REQUEST	Current Zoning: INST(CD) (institutional, conditional) and R-3 (single family residential) Proposed Zoning: INST(CD) SPA (institutional, conditional, site plan amendment) and INST(CD) (institutional, conditional)
LOCATION	Approximately 27.54 acres located on the east side of Park Road between Arbor Pointe Drive and Smithfield Church Road (Council District 6 - Smith)
SUMMARY OF PETITION	The petition proposes the redevelopment of a portion of the Quail Hollow Presbyterian Church property and an amendment to the approved site plan for the existing Southminster senior living community located in the Quail Hollow area.
PROPERTY OWNER	Southminster, Inc.
PETITIONER	Southminster, Inc.
AGENT/REPRESENTATIVE	John Carmichael, Robinson Bradshaw & Hinson, P.A.
COMMUNITY MEETING	Meeting is required and has been held. Report available online. Number of people attending the Community Meeting: 3.

PLANNING STAFF REVIEW

**SCHEMATIC
 SITE PLAN**

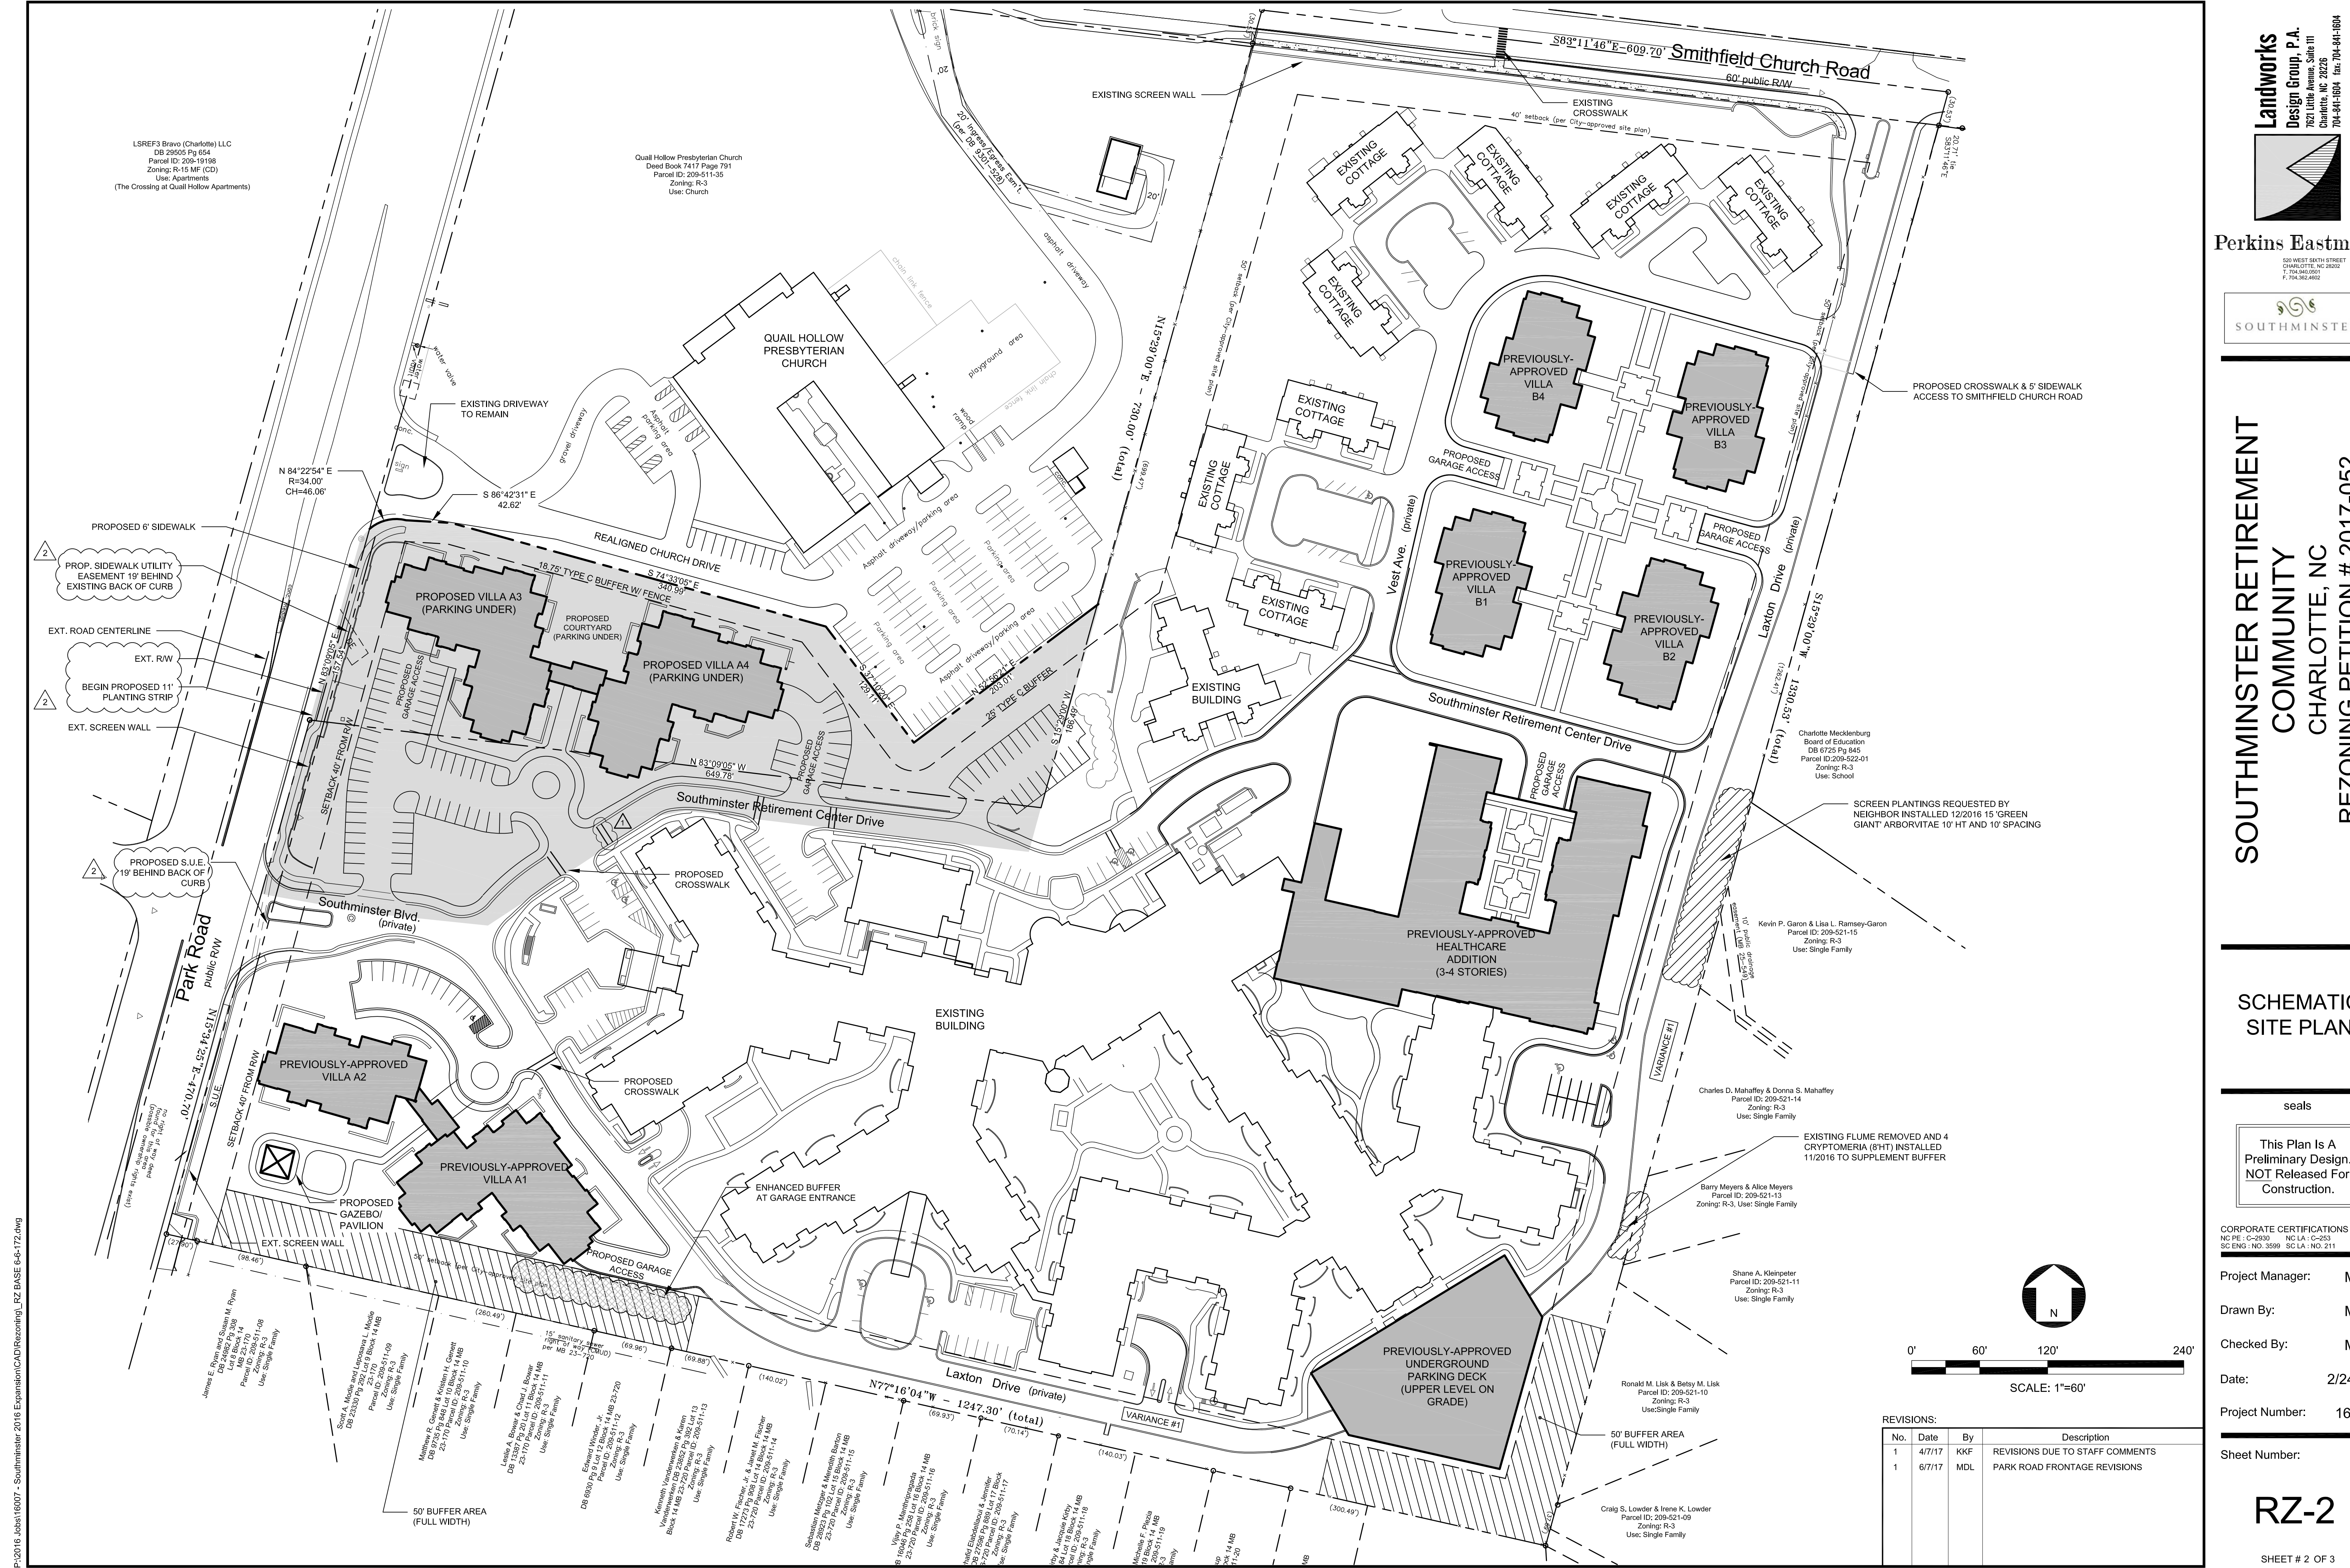
1. Revise the site plan to depict, label, and add a conditional note for an 11-foot planting strip and six-foot sidewalk along the site's Park Road frontage, including proposed right-of-way to be located 19 feet as measured from the Park Road's existing back of curb. The additional planting strip width will accommodate a future buffered bike lane. The proposed six-foot sidewalk and two-foot maintenance strip may be a sidewalk utility easement (SUE).
-
